Harnett County
420 McKinney Pkwy
LILLINGTON, NC 27546
Phone:
Fax:

SUBJECT: SFD2401-0110
SINGLE FAMILY DWELLING

Here are the results of all Inspections located at **47 EAGLE CREST CT:**

SHEET  
**1.1c**

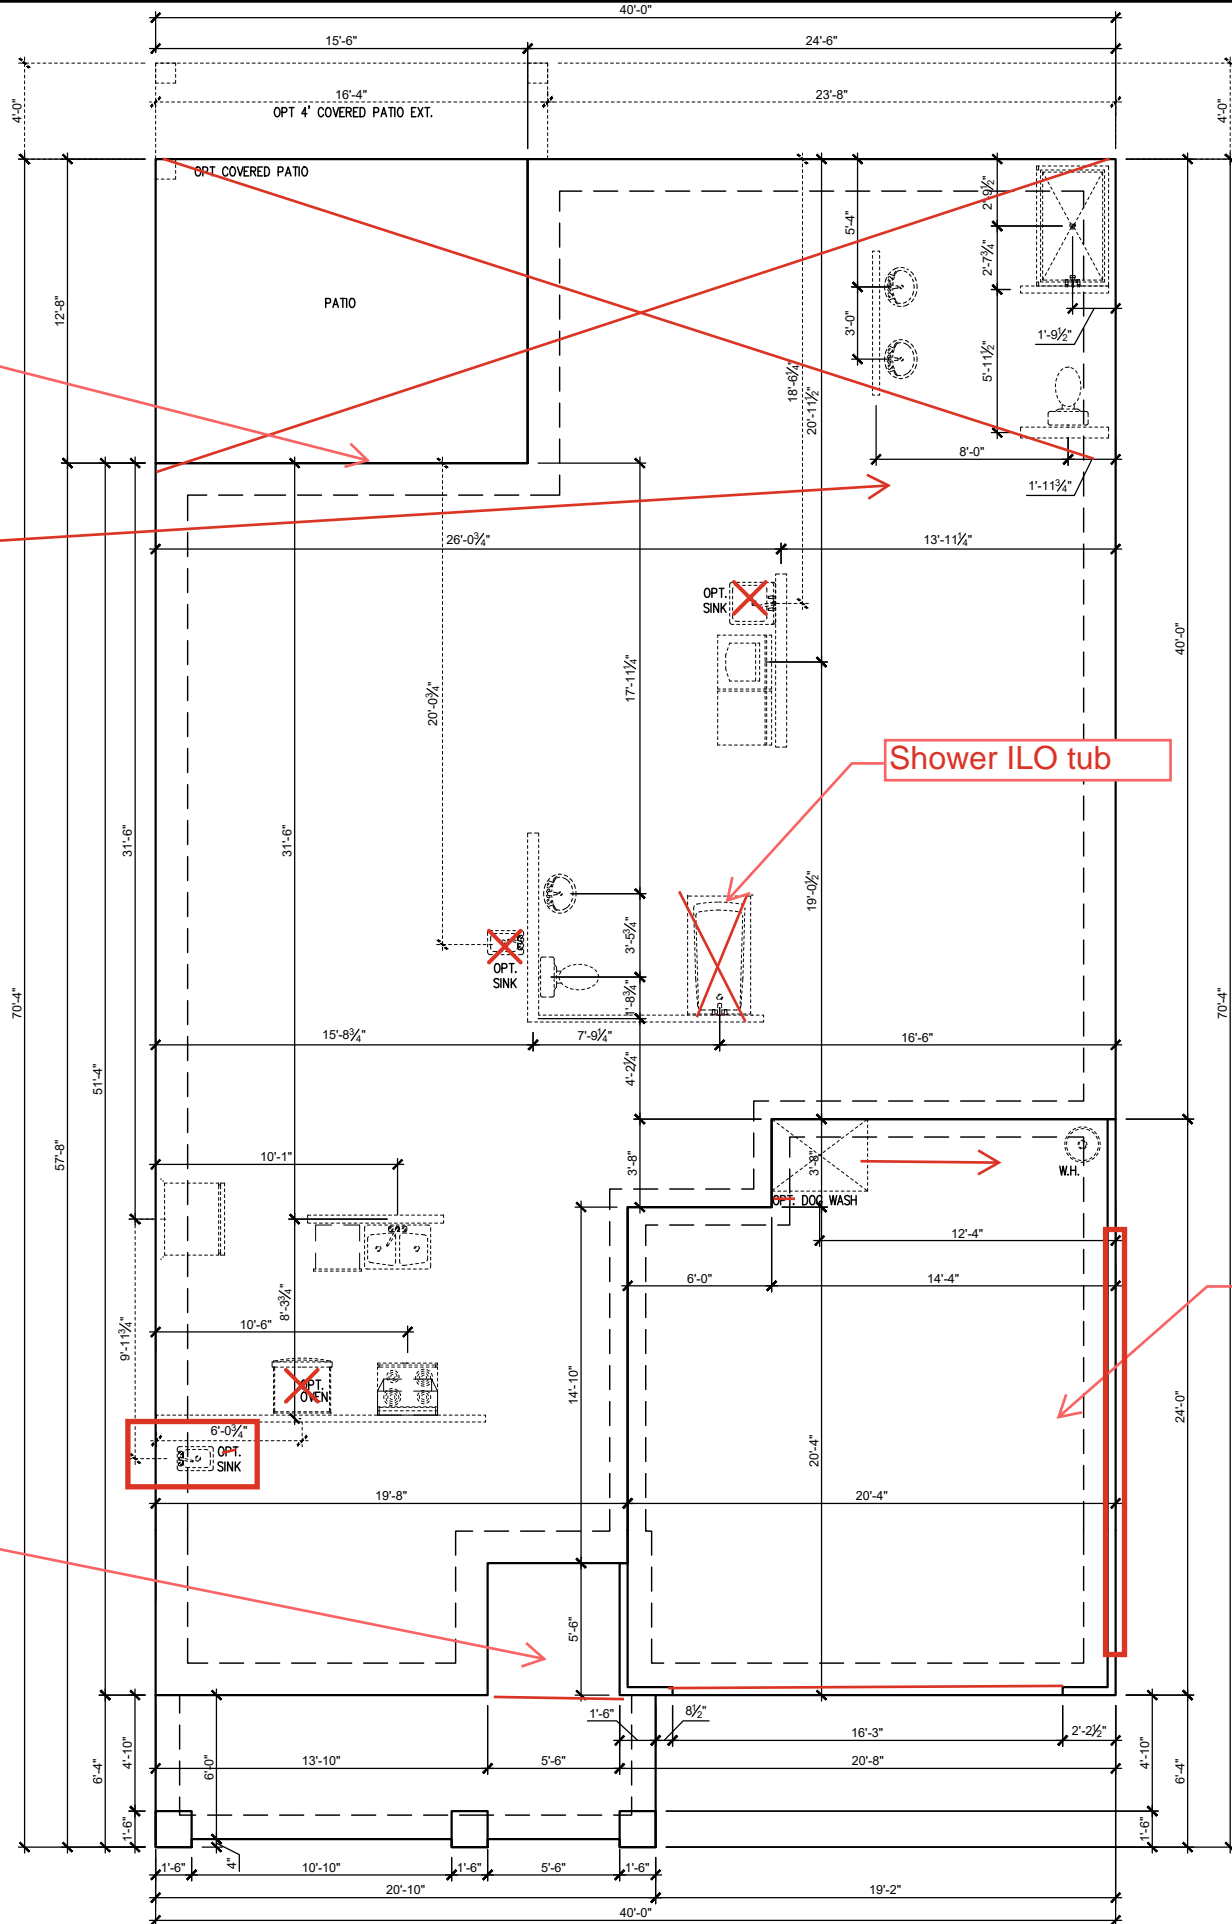
Plans missing sheet for engineered mono slab. Protect all piping exposed to concrete. Missing electrical conduit to island. Note: No rebar for UFER ground installed.

**S-2.1**

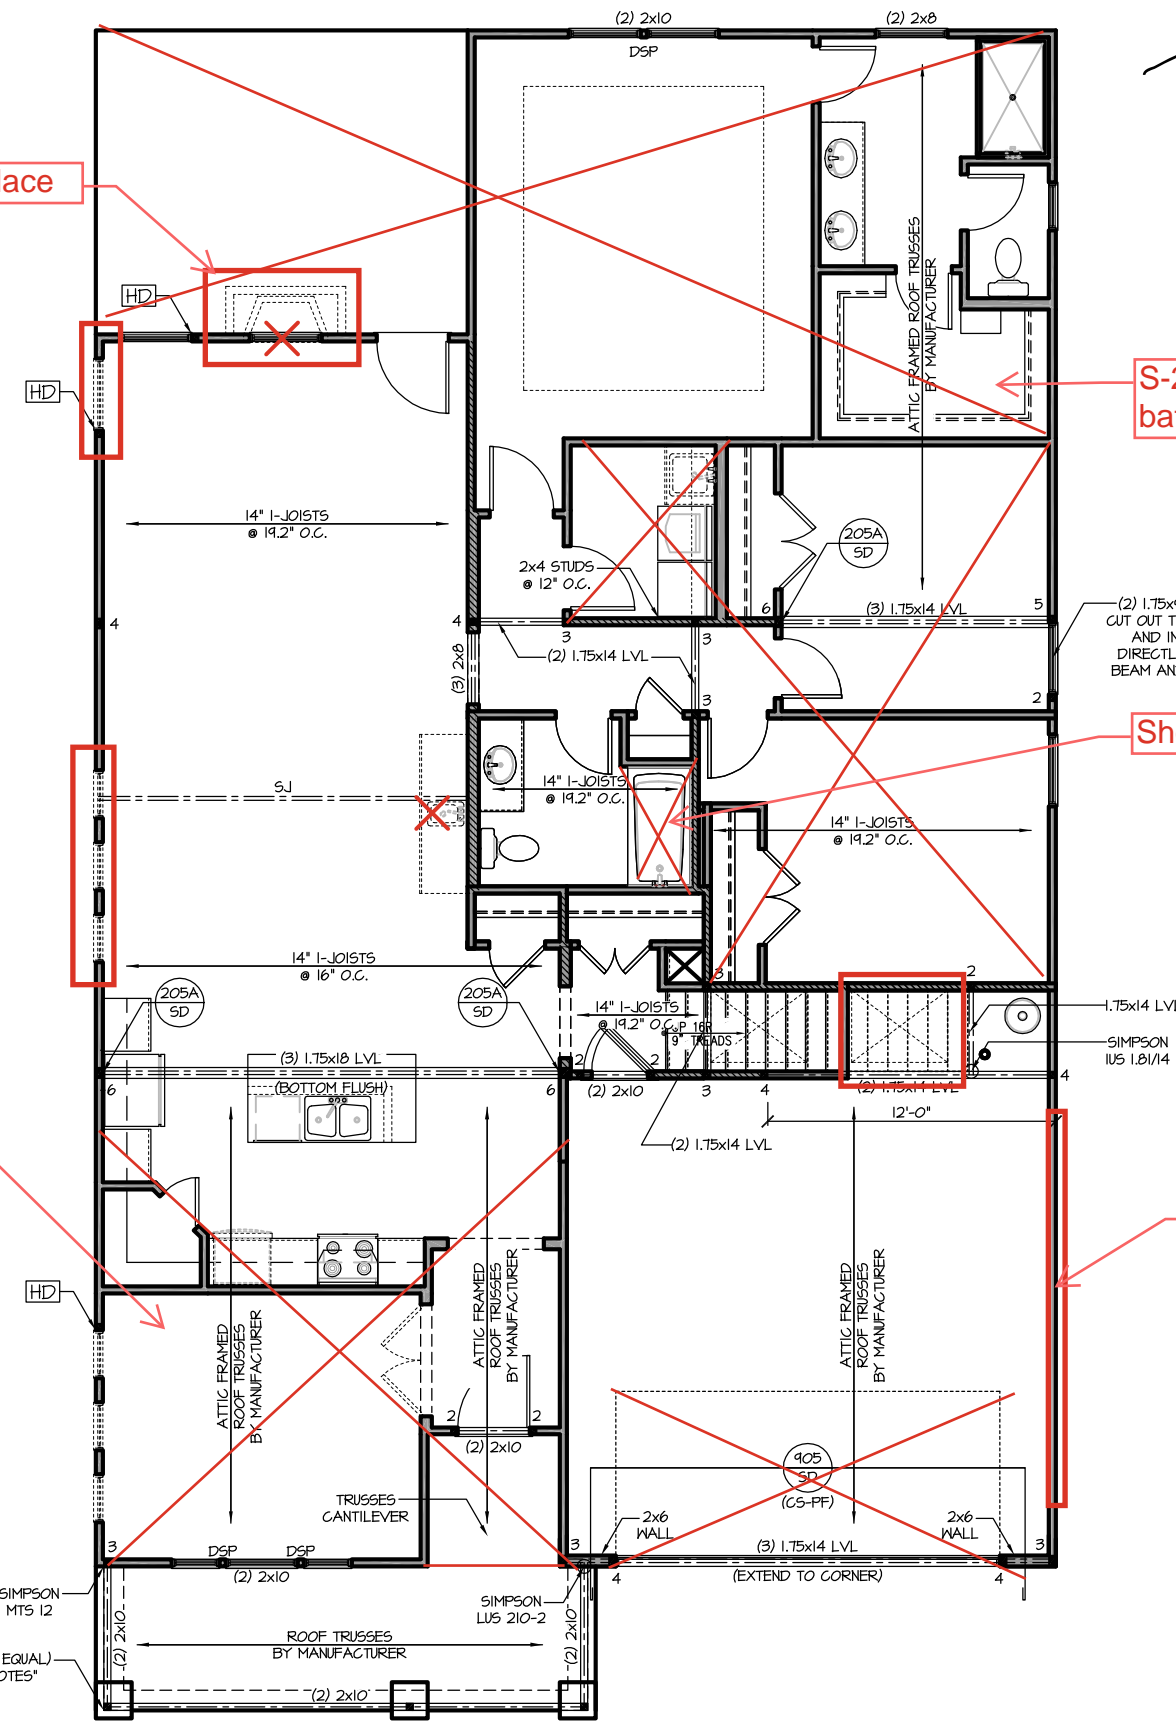
Inspection Type: 1/ nail stud column under two ply roof truss in garage.2/ nail front porch beam into stud
Scheduled Date/Time: pocket.3/ missing fire caulking top plate several locations at security panel 4/ nail three ply lvl
Completed Date/Time: fully in kitchen area. 5/ missing fire caulking top plate left of range location. 6/ missing fire
Inspector: caulking at all low voltage top plate penetrations. 7/ missing hold down bracket bolt left rear
Result: corner. 8/ supply test down 9/ incorrect roof truss hanger nails installed on lvl above main
Remarks: bedroom door. 10/ need legible permitted, house plans 11/ missing nail plate for low voltage
Notes: conduit in second floor bathroom. 12/ no drain system test. 13/A05 truss missing bracing 14/
A03, A04 missing bracing 15/ A17 missing bracing 16/ gas test at zero 17/ install house wrap
correctly around dormer window. Note : Contractor arrived during inspection and began
